# Rezoning Transportation Analysis

Petition Number: 2025-056

## Revision Log:

Date	Description
6-25-25	First Review (CM)
7-24-25	Second Review (CM)

**SCHEMATIC
SITE PLAN**

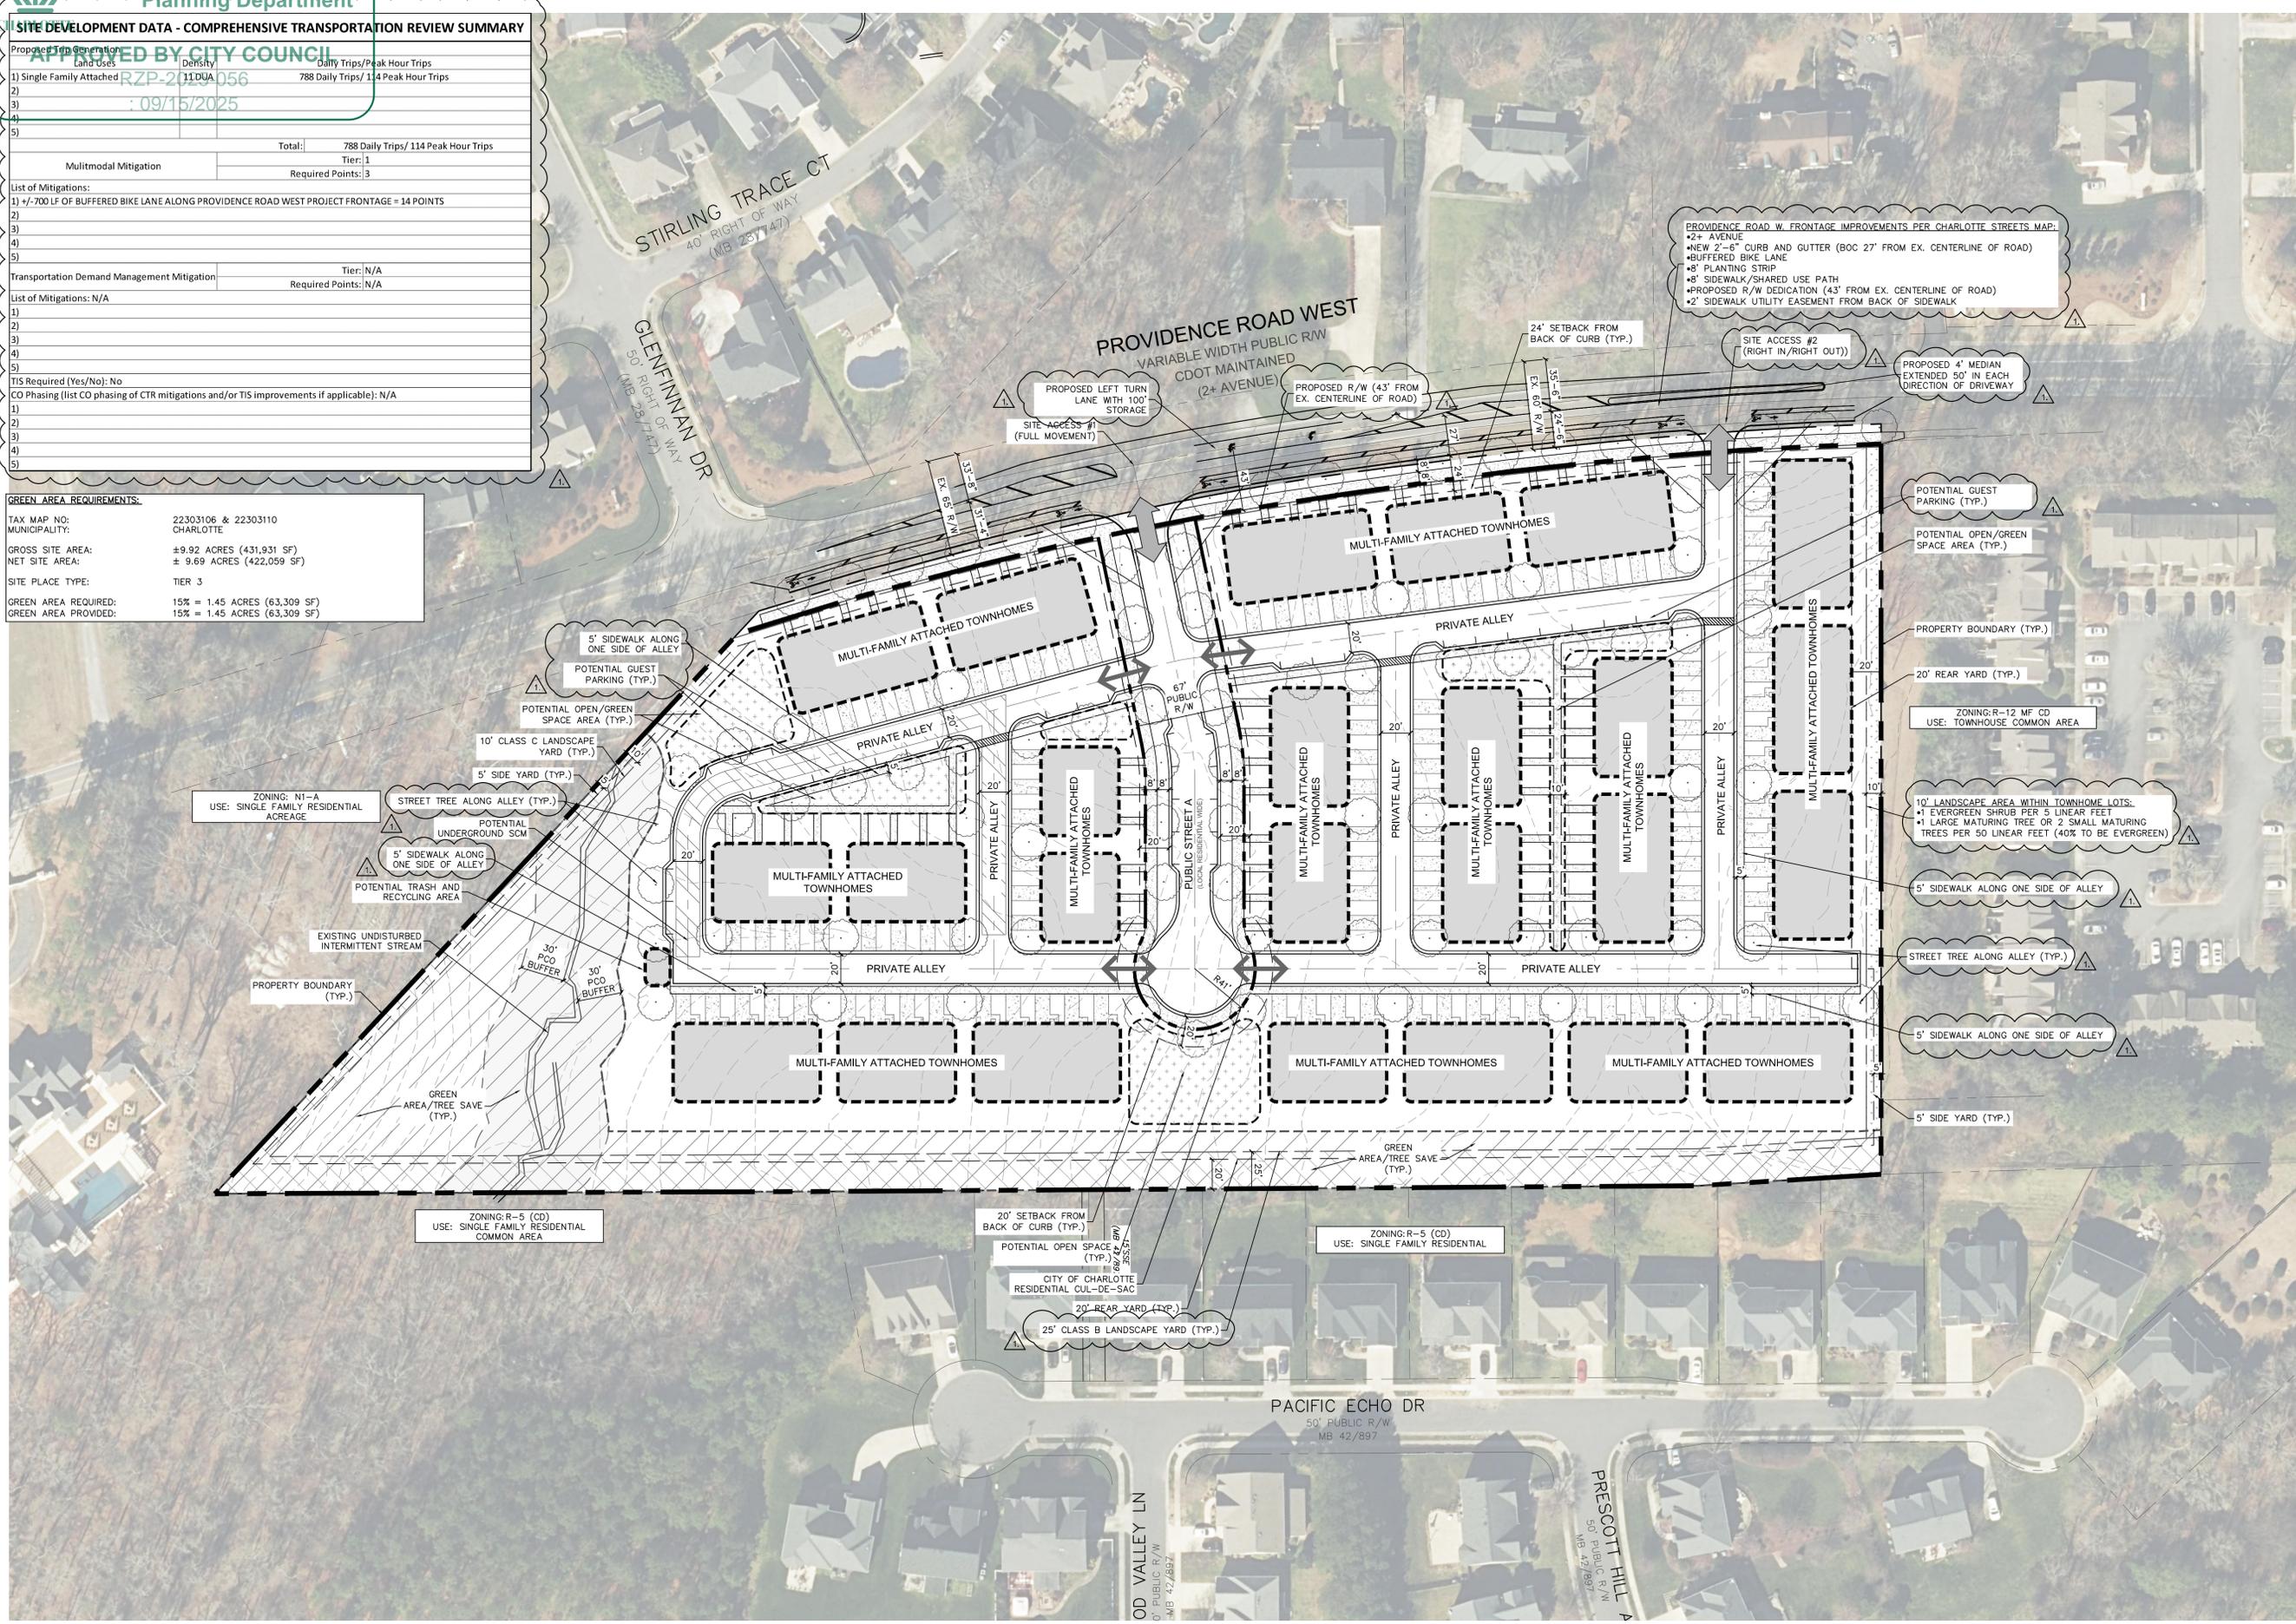
- a. ~~Providence Road West~~ : Location of future curb and gutter is 27' from road centerline. Curb and gutter will need to be constructed in this location.

~~Label and dimension the curb and gutter from the centerline for each road on the site plan.~~

3. ~~Revise site plan and conditional note(s) to commit to dedicate 43' right-of-way from the road centerline. The site plan shall label and dimension the right-of-way from the road centerline.~~
4. ~~Revise site plan and conditional note(s) to commit to construct bicycle facilities by locating the curb and gutter 27' from the center line in accordance with the council-adopted Charlotte Streets Map. Multi-use paths maintained by the City shall meet ADA/PROWAG requirements.~~
5. ~~Revise site plan and conditional note(s) to show Site Access #2 as Right-in, Right-out only with 4ft wide median extended 50ft in both directions past the driveway. Access #1 can remain full movement. Widen~~

~~Providence Road West to provide a left turn lane with a minimum of 100' of full width storage at Access #1.~~

- ~~6. Revise site plan to show road Providence Road West centerline at centerline of roadway. It may just be an offset aerial that is causing the roadway centerline to appear on the north side of the double yellow.~~
